Annex 1 – Oxfordshire County Council’s response to Cherwell District Council’s consultation dated 14 March 2011 on AMENDED application for Phase One North West Bicester Eco-town (no: 10/01780/HYBRID): Detailed comments

2. Social and Community Infrastructure: Proposed School Site

3. Transport

Drawing No. 7153 — Project No. UA001881 — Issue 02

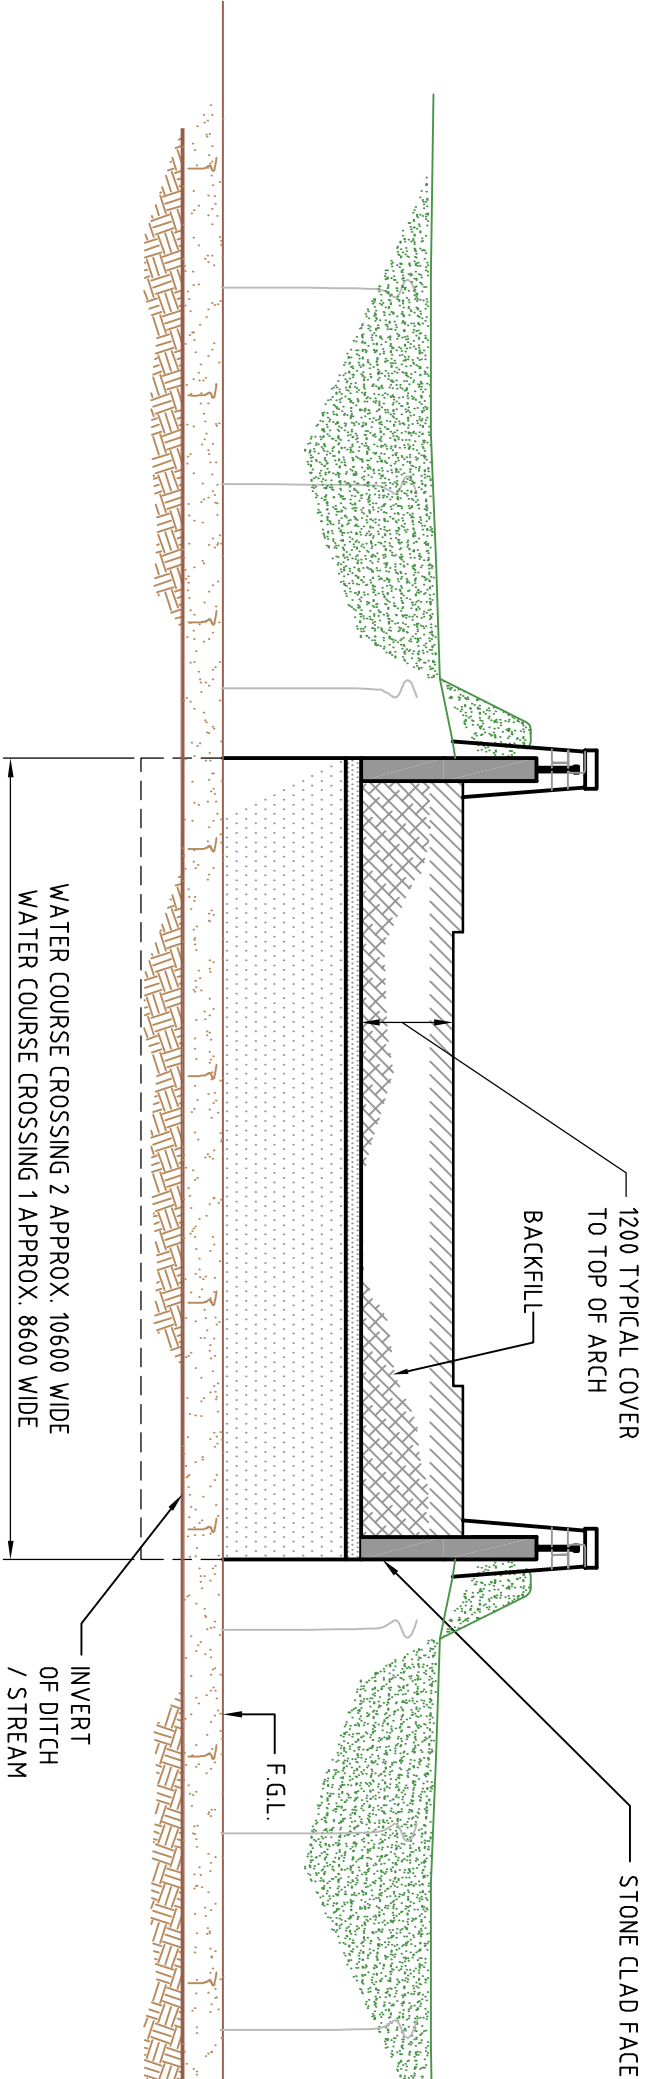
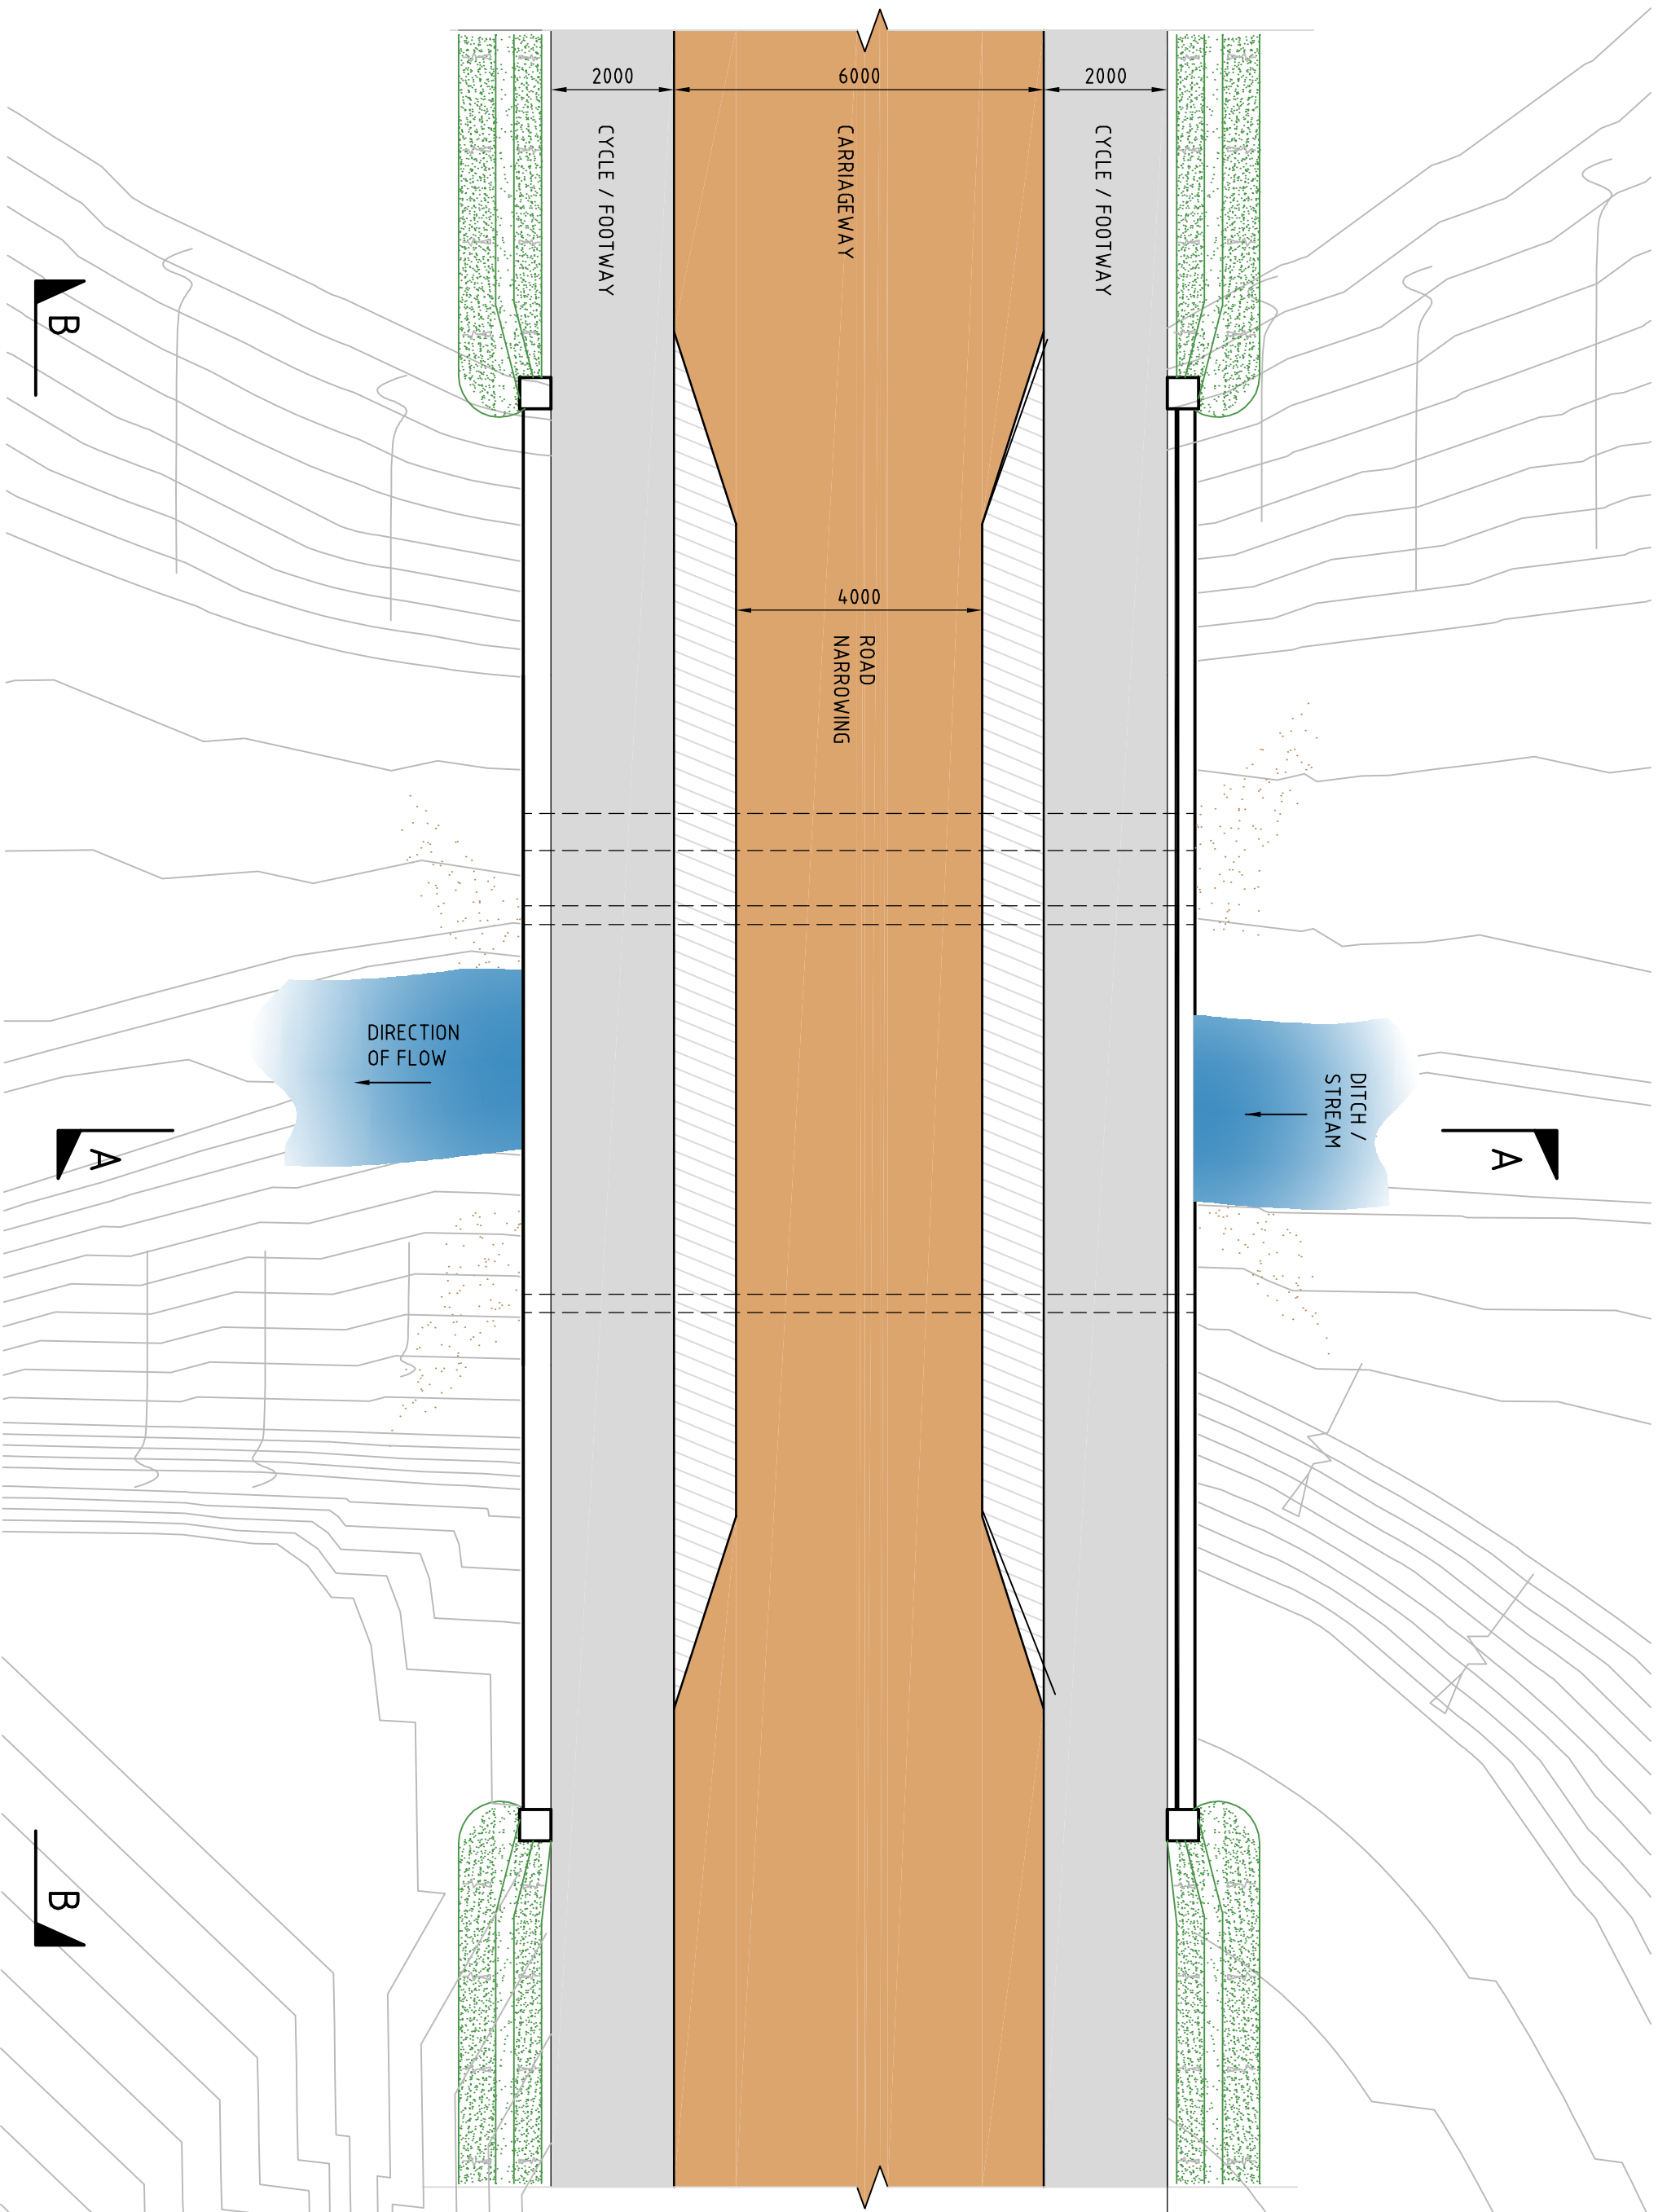
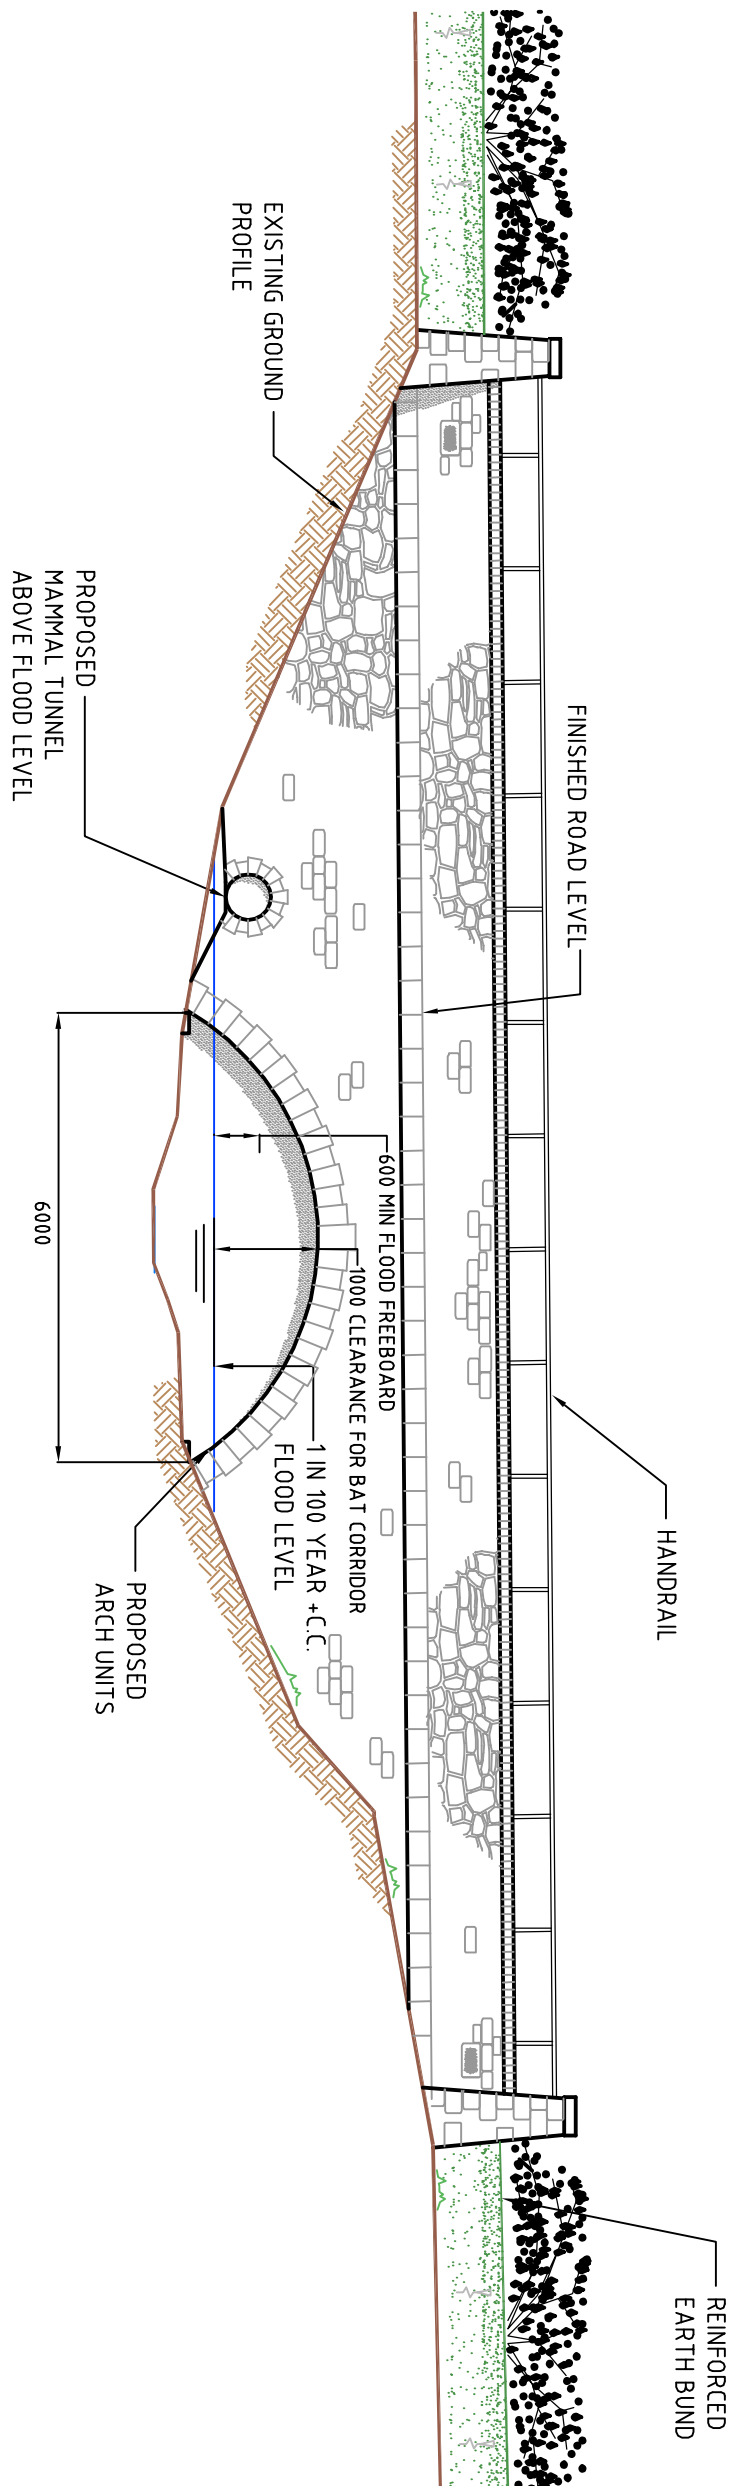
- Drg 7153 – No drainage shown on road narrowing on bridge;
- Drg 8005 – Access to ponds / swale for maintenance / footpath, cycleway, footbridge strong enough;
- Drg 8004 – same as above;
- Drg 8003 – same as above;
- Drg 8003 – Landscape Master Plan – same drg no. as above;

Figure 5.4

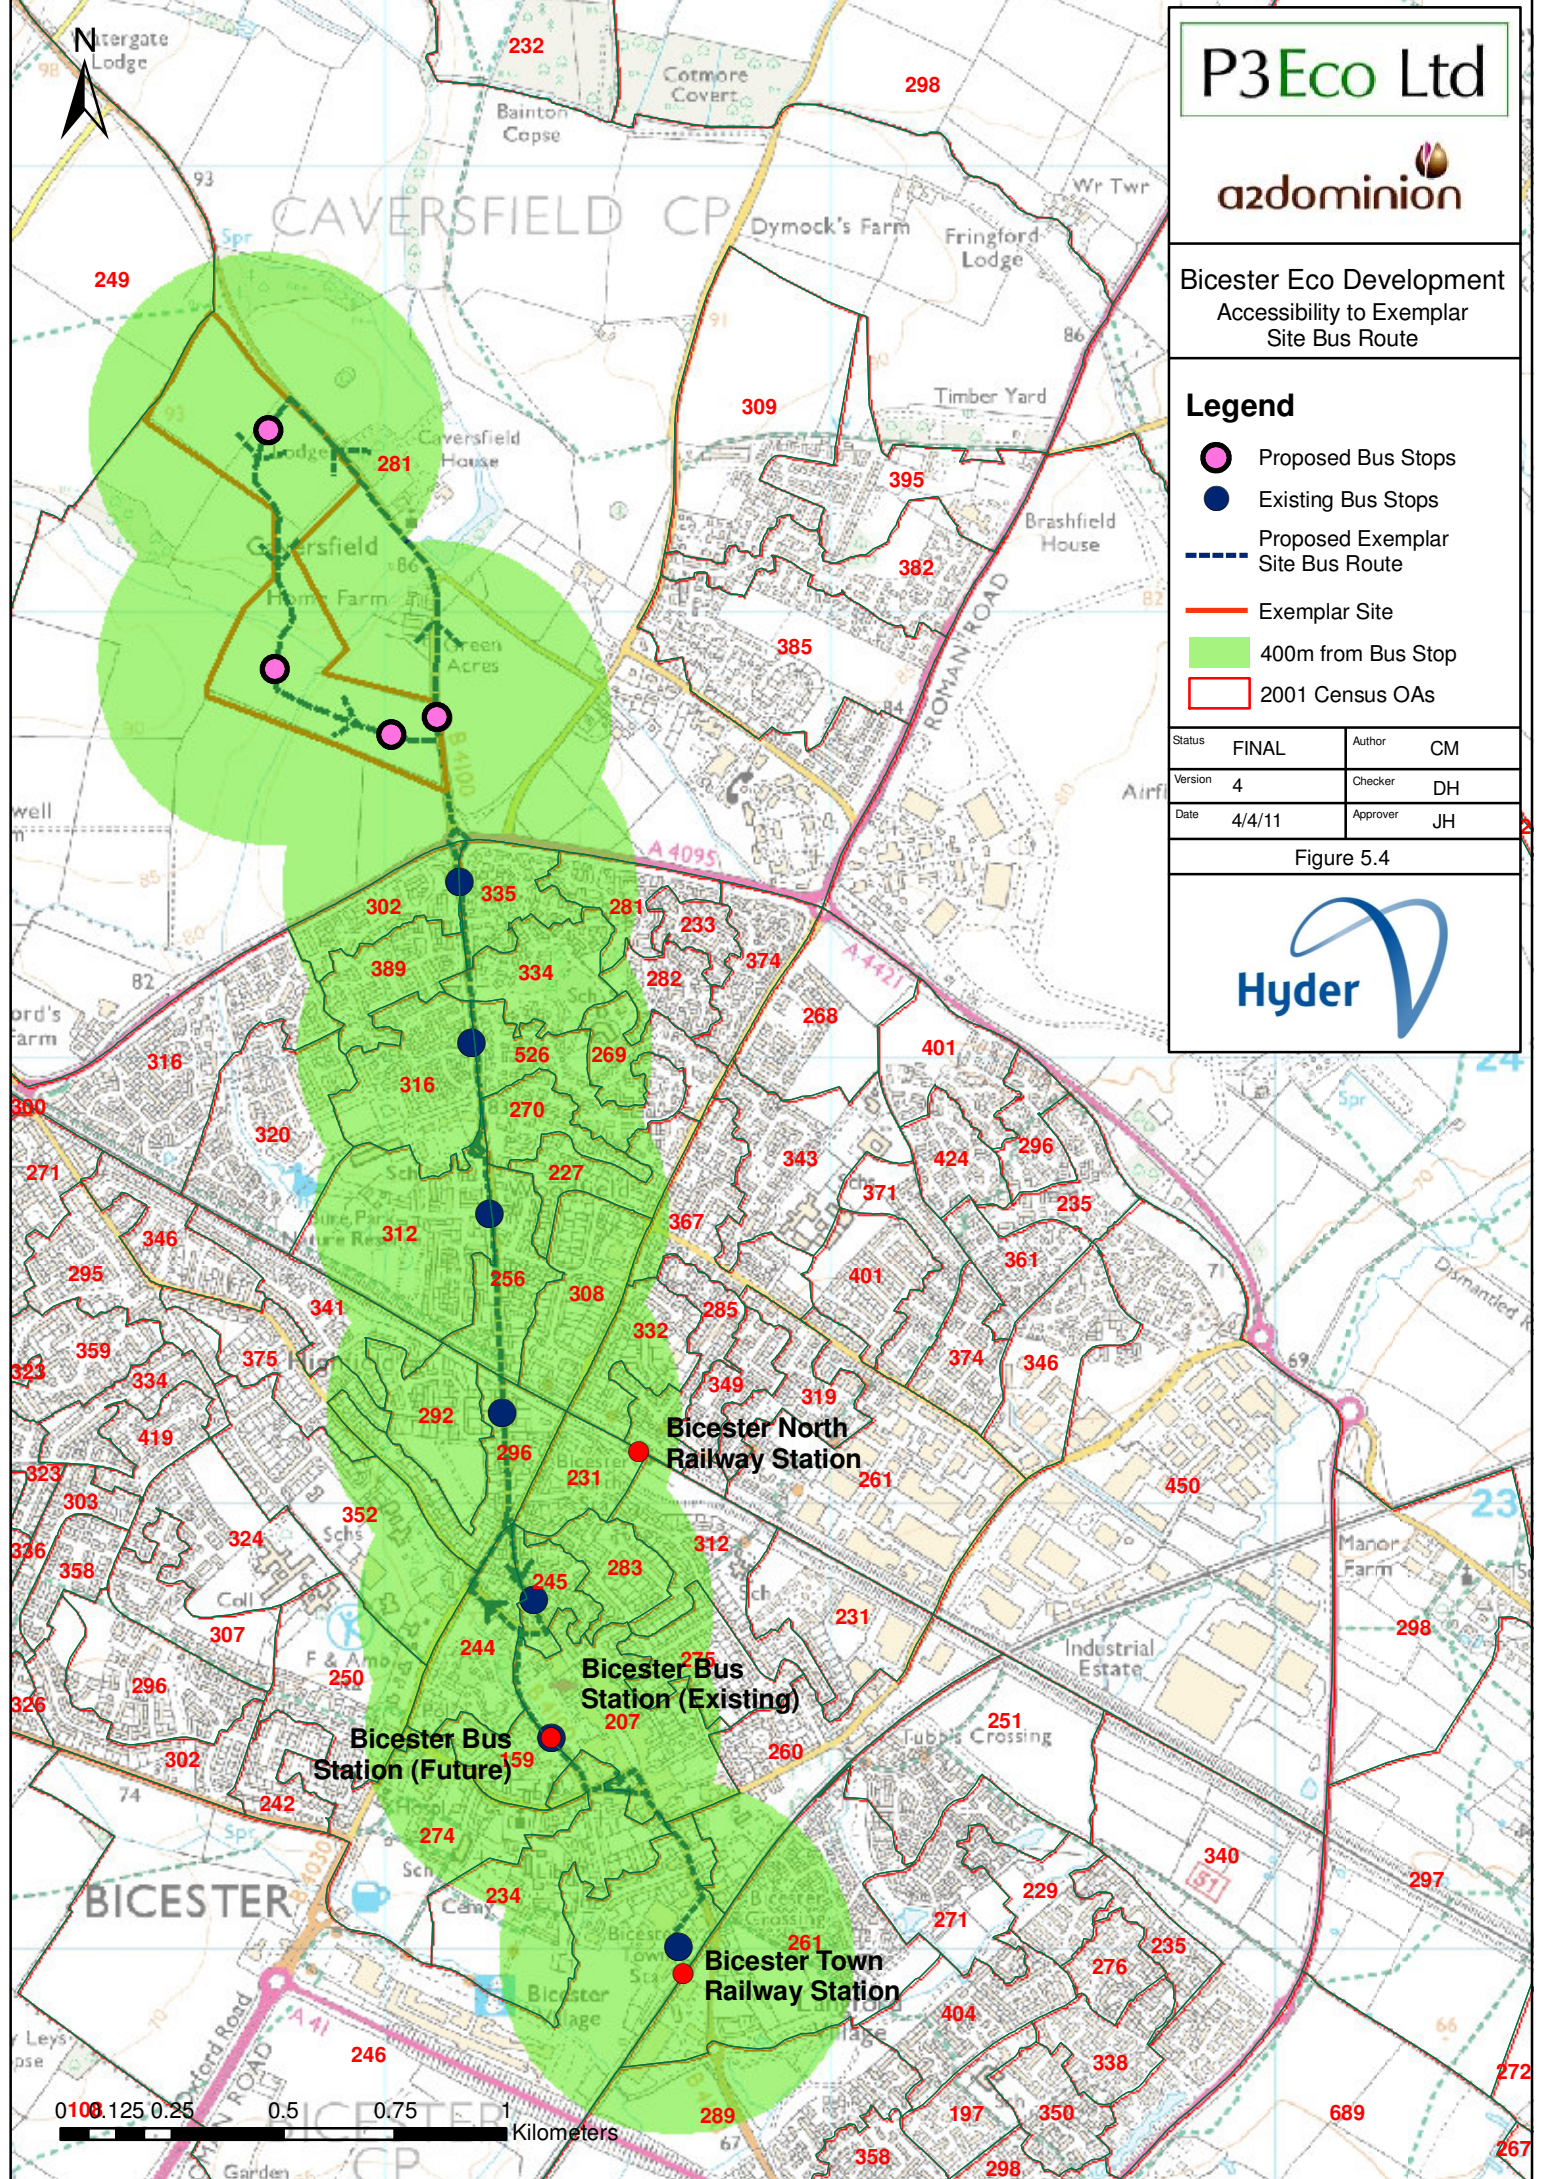
Figures 5.2, 5.3 and 5.4 show a bus stop outside the eco business centre, but it is missing on the South Field Site Plan (BIMP2_PA_03_007 REV C). The bus stop close to the school needs to be moved away from the junction and the bus stop in the northern fields needs moving to connect better with pedestrian movements across the site.
